DEVELOPMENT FACILITATIVE TEAM (DFT)

Code Enforcement Comments

PR-2022-007805

SI-2024-00849 – SITE PLAN DFT

A1 SITE PLAN - DFT
SCALE: 1" = 80'-0"

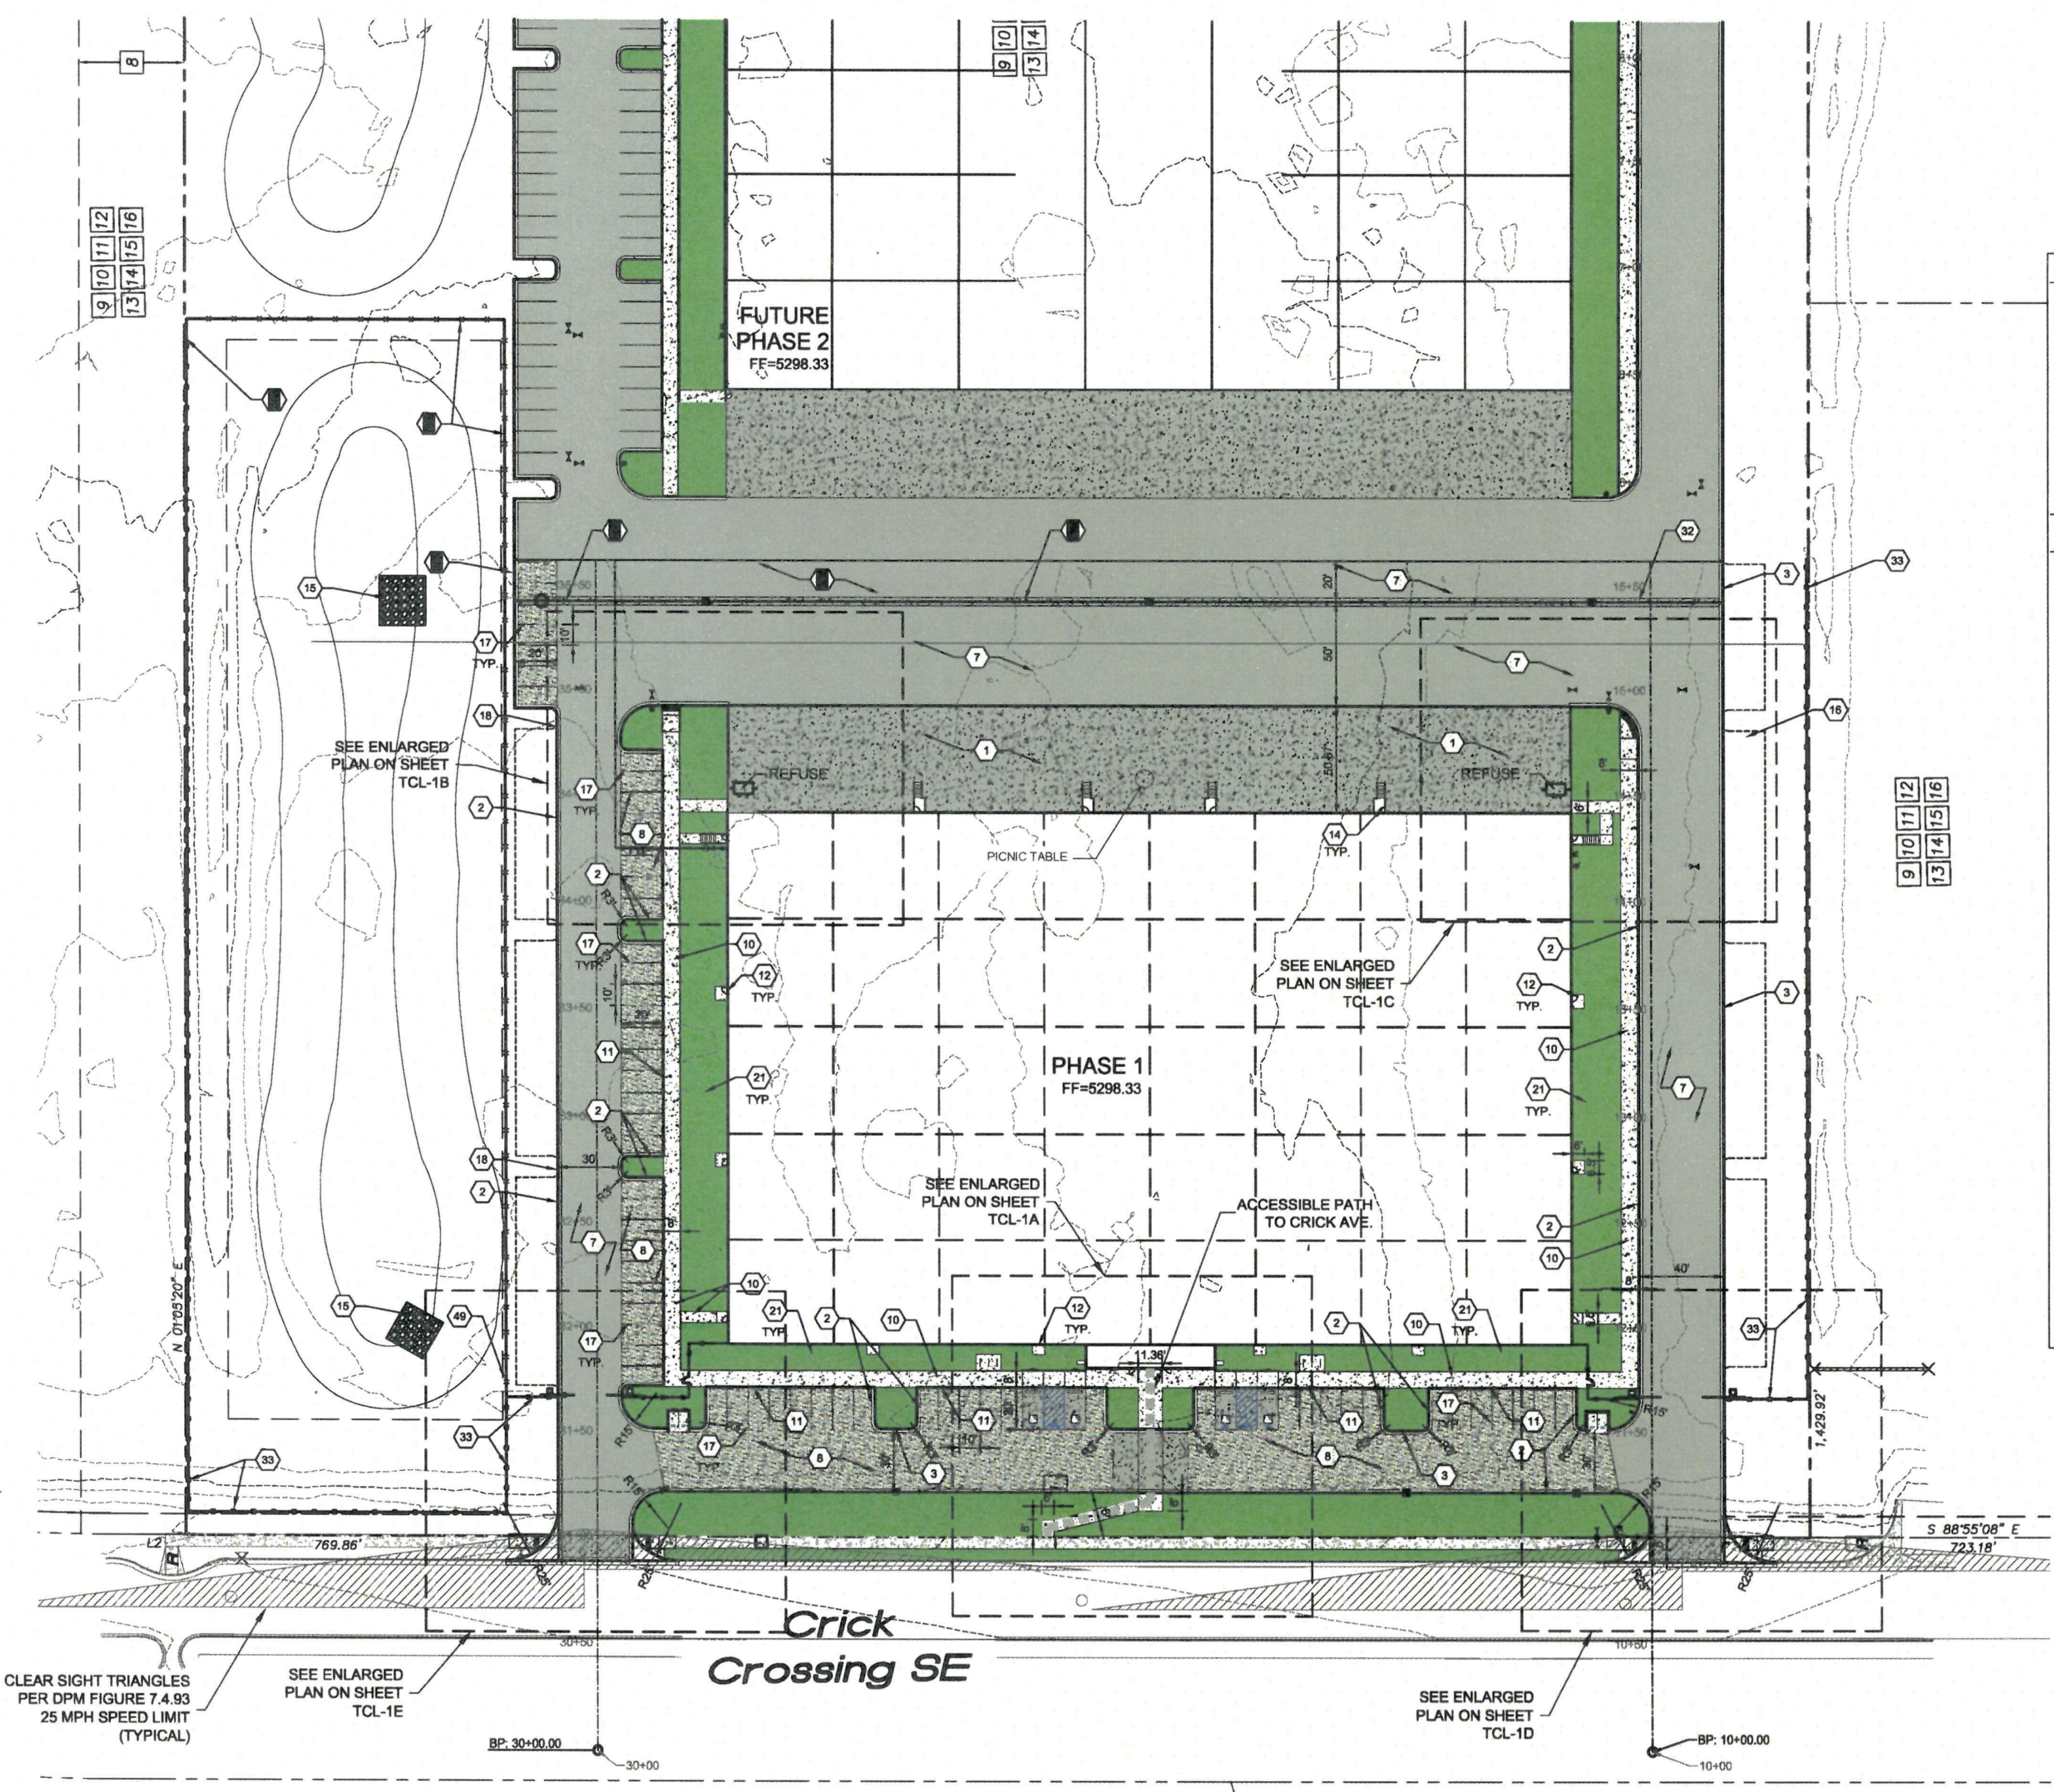
1. This property is in Mesa del Sol PC -Employment Center and requires the Architecture Review Committee approval for to approval. Approval was completed 5-10-24. Included in package.
2. The AGIS map is Crick Crossing not Crick Ave SE and needs to be addressed. Changed.
3. This property is in the Airport Protection Overlay Zone provide approval from the City's Aviation Department. Approval was completed xxxxx. Included in re-submittal.
4. Indicate that the project will meet the required reflectivity requirements as approved by City Aviation. Approval was completed xxxxx. Included in re-submittal.
5. Provide the parking calculations and showing the uses within the building. Uses for this structure will be limited to the available parking as per the IDO allowance. New sheet added.
6. Code Enforcement has no further comments at this time.
